MECKLENBURG COUNTY
Park and Recreation Department

MEMORANDUM

RE: Rezoning Petition #2019-160 – Meritage Homes of the Carolinas, Inc.

Conceptual Site Plan

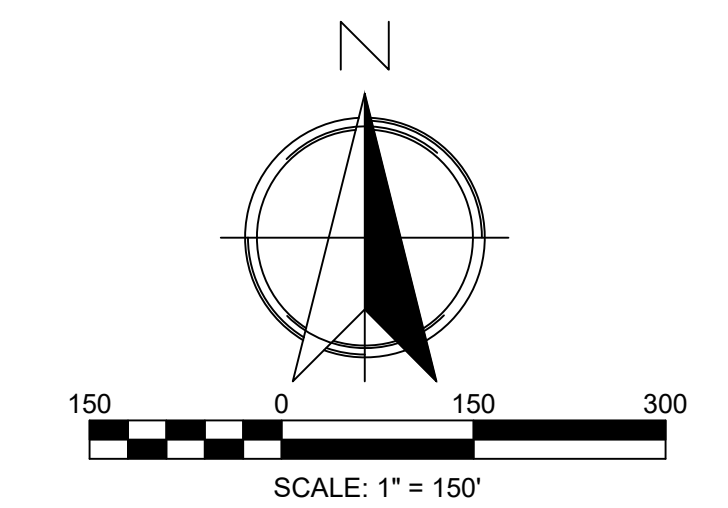
This petition is on Gutter Branch Creek that is a future greenway according to the MCPR 2008 Greenway Master Plan. We request the dedication and conveyance of the 100' SWIM Buffers and the remaining property to the north property line to Mecklenburg County for future greenway use. We also request a minimum of 2 acres to be dedicated and conveyed to Mecklenburg County for the future neighborhood park. This requested park land shall be adjacent to a public right-of-way for access and is conducive for the development of the typical amenities found in a neighborhood park.

The Dedication Areas to the county on the revised Site Plan have been addressed per our third Comment Letter.
